From: Sue Howell <Sue.Howell@arun.gov.uk>
Sent: 17 June 2021 14:58
To: Planning.Responses <Planning.Responses@arun.gov.uk>
Cc: Simon Davis <Simon.Davis@arun.gov.uk>
Subject: FW: Planning Consultation on: AL/20/21/PL

Application ref: AL/20/21/PL

Description: Demolition of Wings House & erection of 71 No. replacement dwellings (70 net new dwellings), access arrangements, sustainable drainage measures, public open space, landscaping & all other associated works (resubmission following AL/46/20/PL). This application is a Departure from the Development Plan.

Location: Land At Wings Nursery Lidsey Road Woodgate PO20 3SU

Appendix 6 - development proposal plan

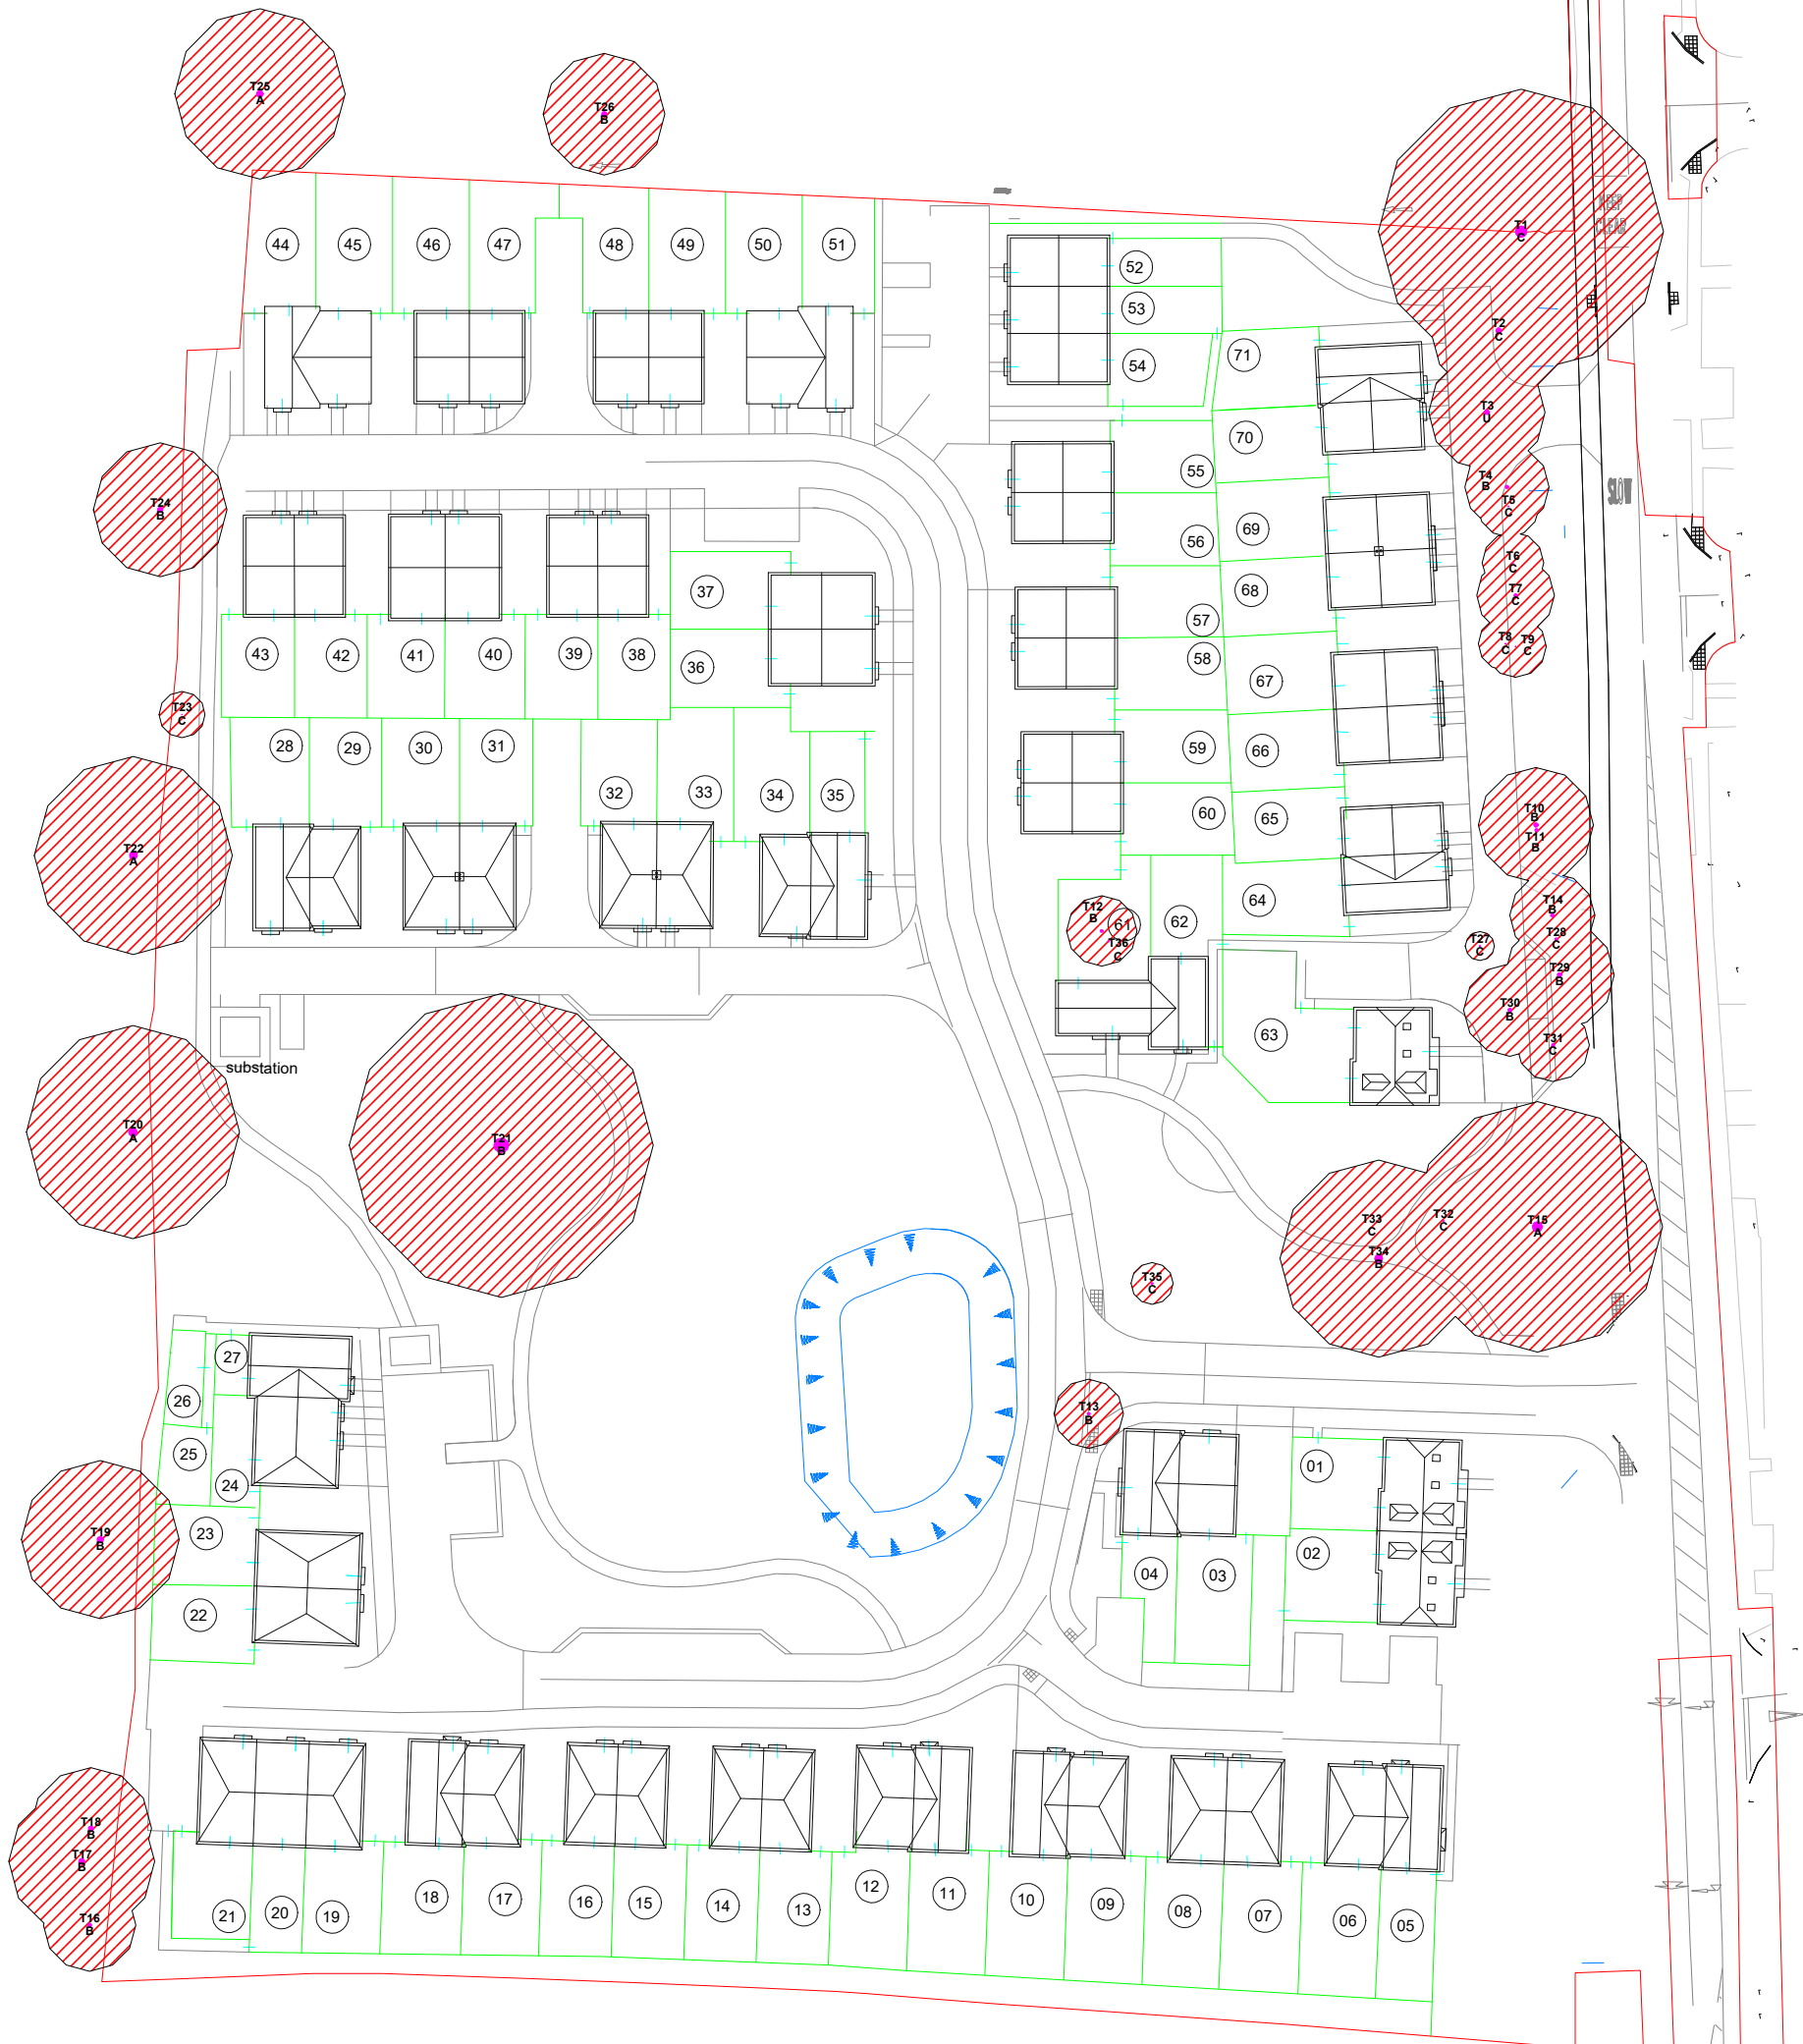
The Landscape Masterplan 01 D shows an improved POS offer with green connection across the site which is good to see.

The indicative layout appears to show an area detailed as potential SuDS within the POS area. Should the need for SuDS be required with the development then these areas should not be included in the total area of usable POS calculations. Further detail would also be required regarding depths and indication of timeframe for water holding periods ie dry feature or water holding body. This would be particularly relevant because of the proximity in relation to play and dwelling boundaries.

Consideration of existing trees and hedges within the site would be required and any removals agreed with Arun District Councils Tree Officer. Existing vegetation to the perimeter of these proposals may conflict with private gardens and come under pressure to be removed or pruned. It is good to see that the indicated green buffer shown to the boundaries of this development would go some way to accommodate existing trees and allow for their retention.
